Application: SSI 7485

I write regarding the proposed modification to M4-M5 Link, Mod 2 The Crescent overpass and changes to pedestrian infrastructure in North Annandale, Rozelle and Rozelle Bay Foreshore area.

Figure 4-5 The Crescent/Johnston Street/Chapman Road intersection

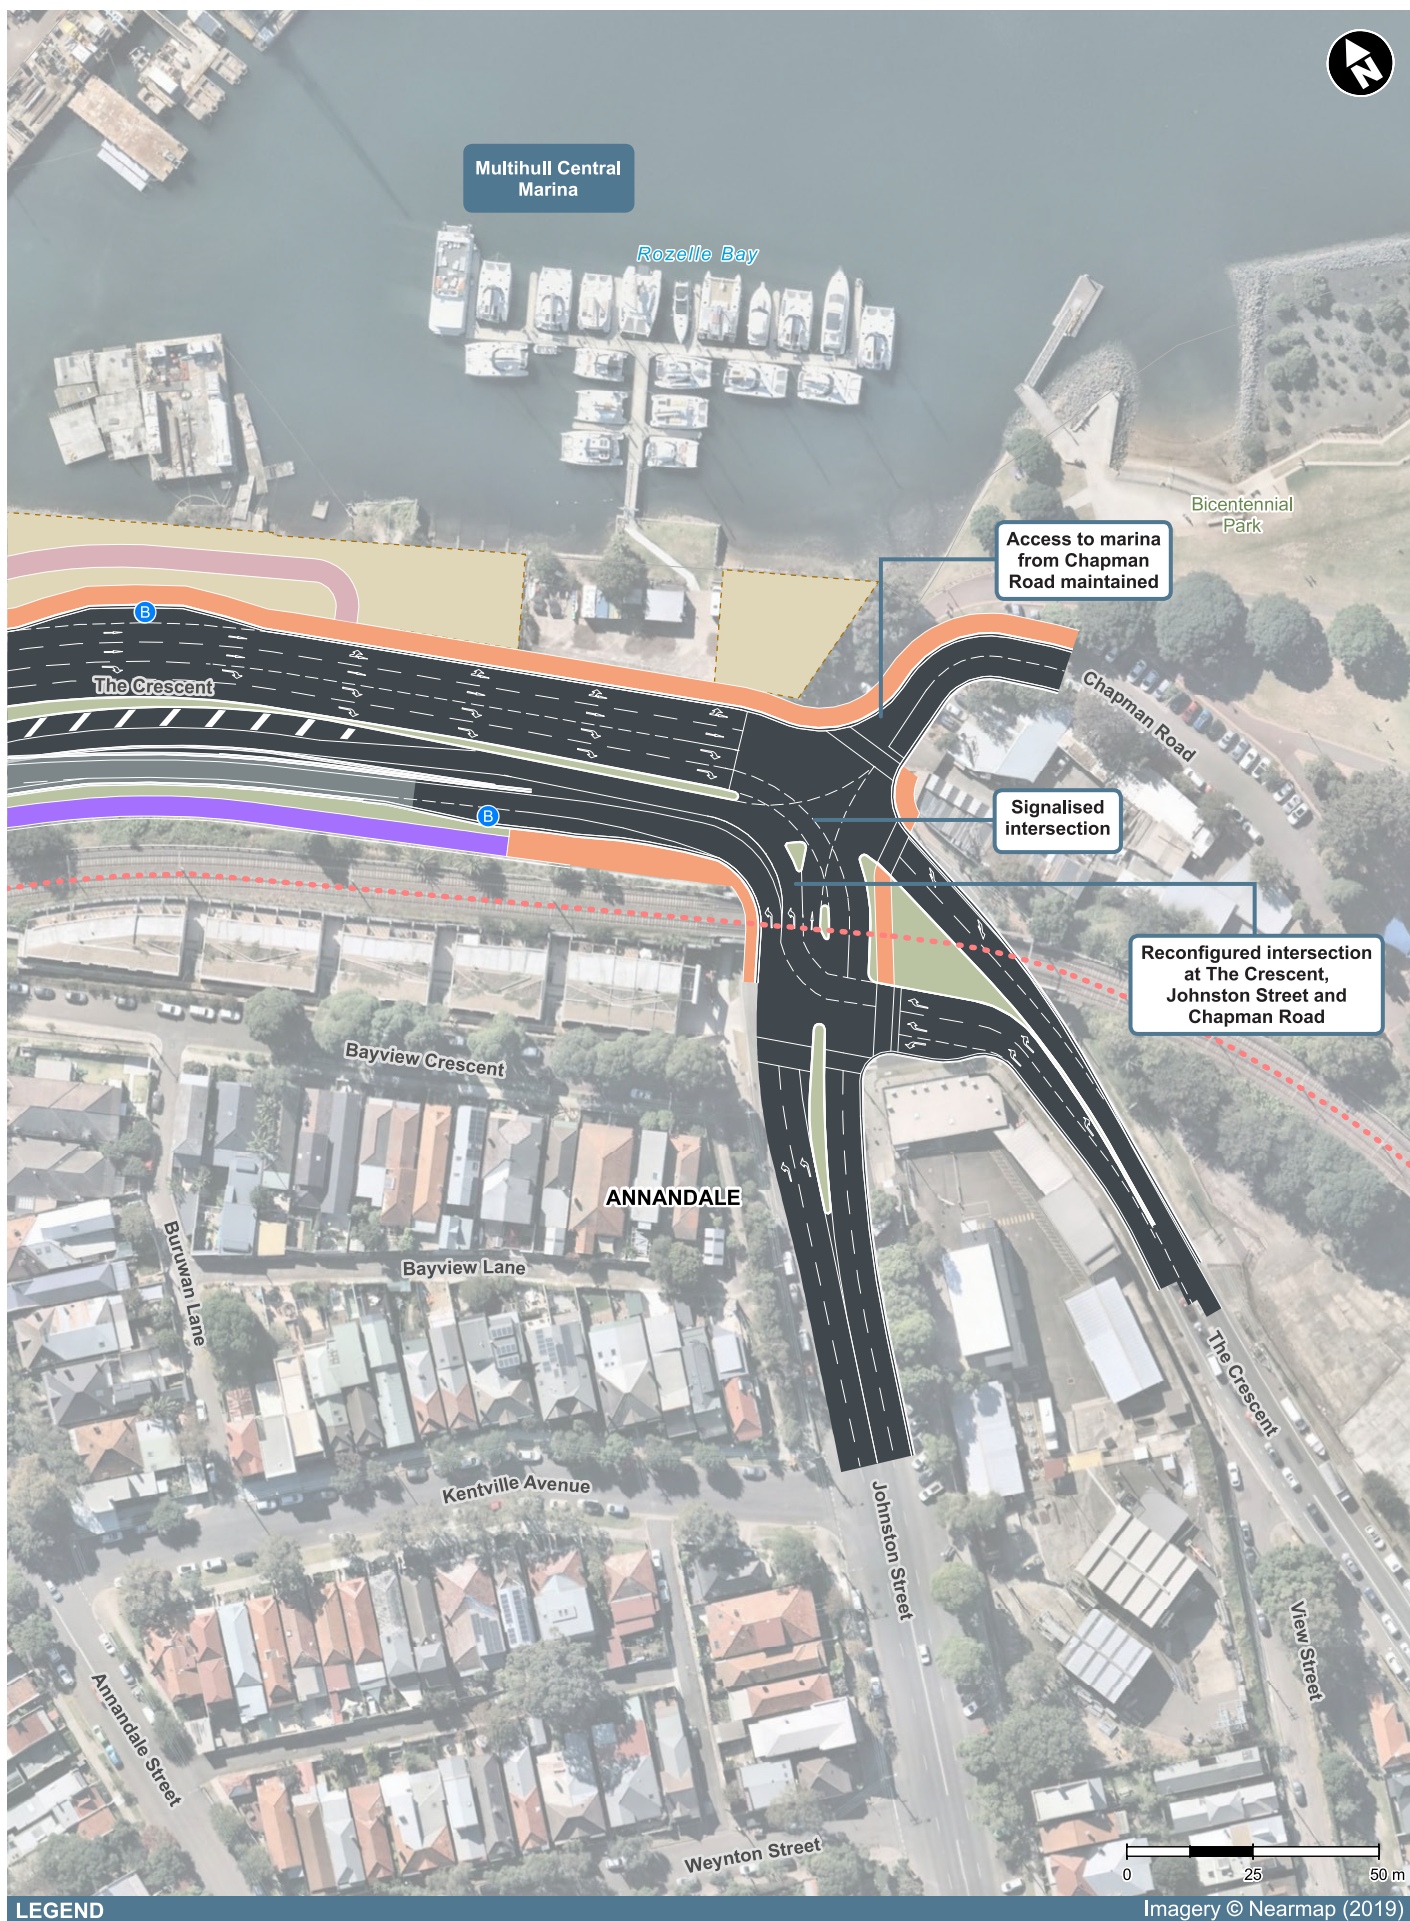
The proposal bottlenecks the majority of vehicle movements turning right to Victoria Road and the Anzac bridge from three lanes down to one lane with likely traffic impacts up Johnston street and The Crescent.

It doesn't allow a right hand turn into James Craig road.' From The Crescent heading city bound.

Return the Johnston Street / The Crescent pedestrian crossing to a single traffic light as per the current situation, and location.

Figure 4-6 Elevation: Indicative view of Rozelle Rail Yards Pedestrian and Cycling Green Link

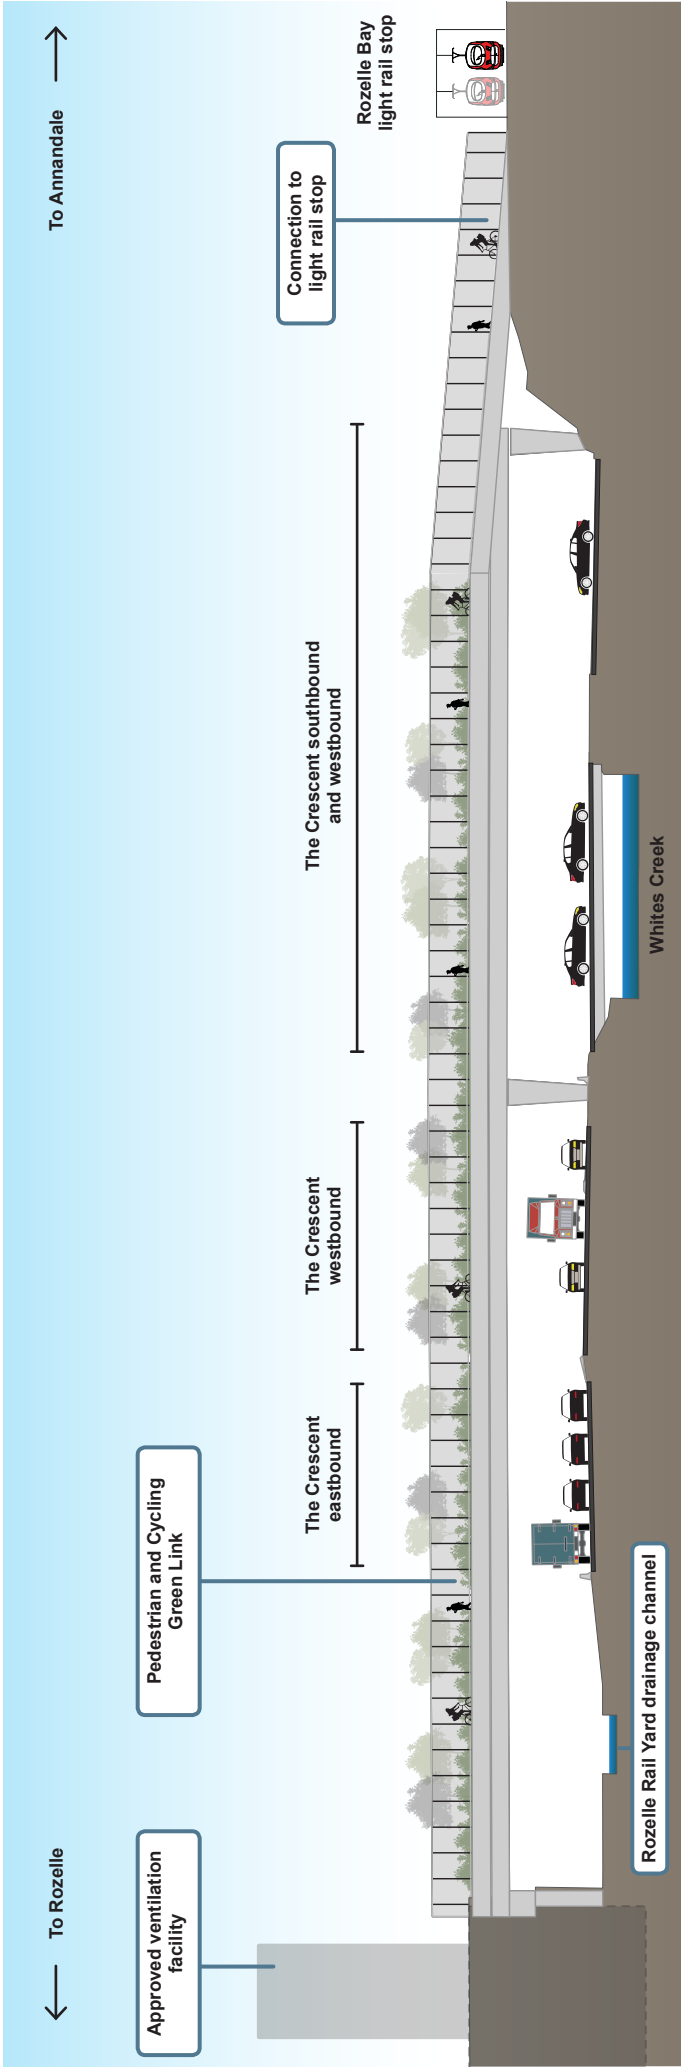
The overpass has significant visual and urban impacts. It has forced the relocation of the green bridge west of The Crescent requiring a pedestrian crossing of four traffic lights.

- **Reinstate the GreenLink connecting communities and green open space from Rozelle to Bicentennial Park**
- **Improve pedestrian connectivity.**

Figure 4-7 Elevation: Indicative view of the shared user path bridge

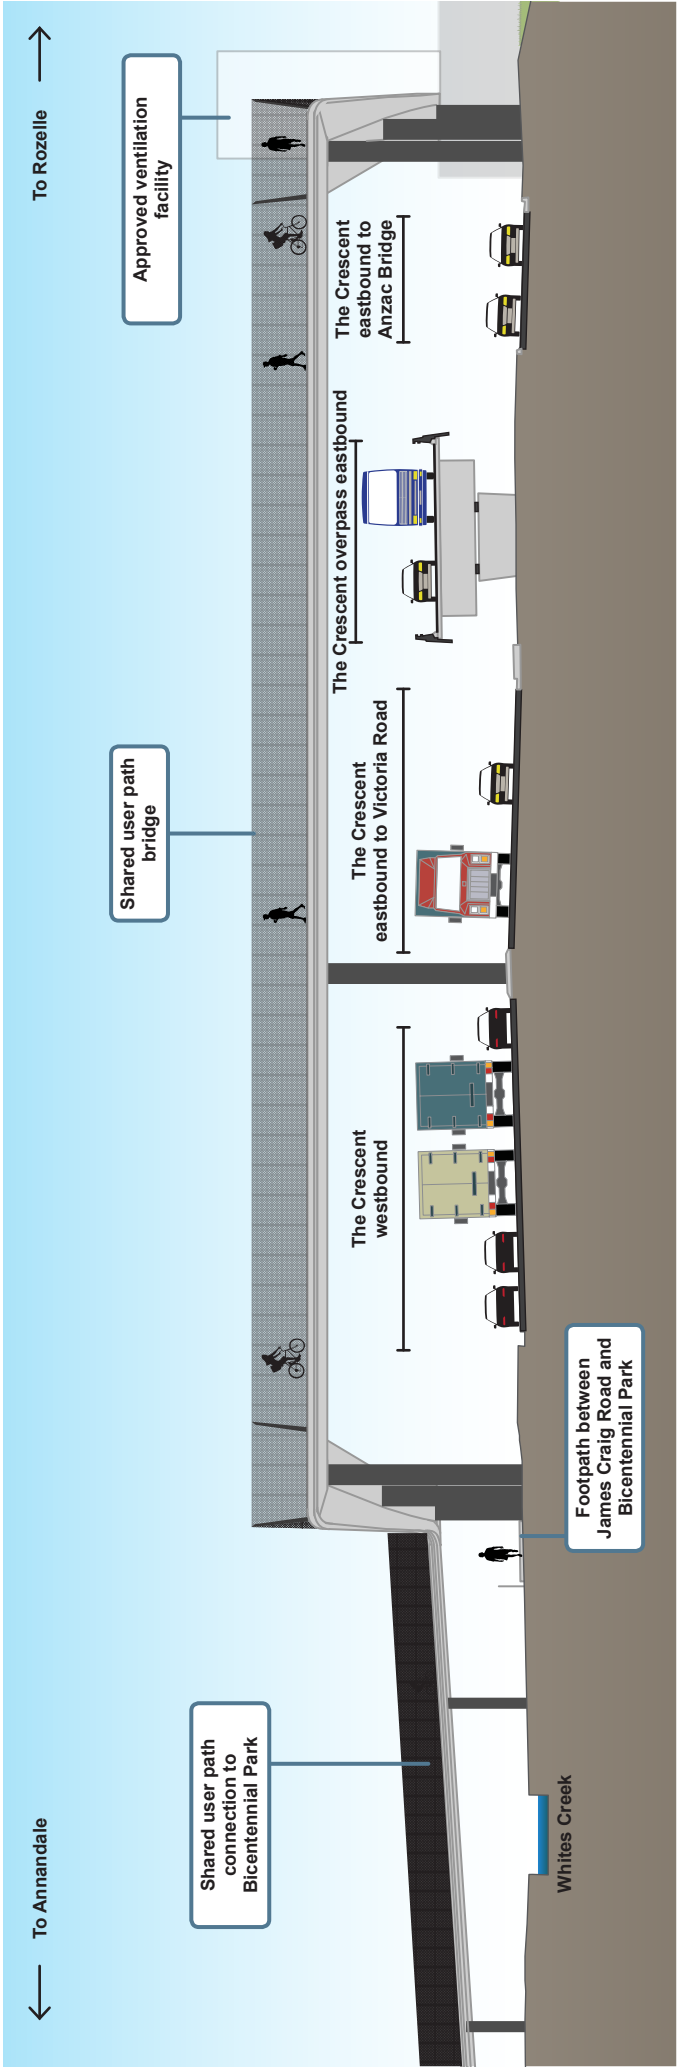
It has added another elevated pedestrian crossing from the same starting point in the new Goods yard parklands. This crossing is longer than it needs to be due to extra height required to get over the new vehicle overpass. These changes have greatly added to the visual impact and clutter.
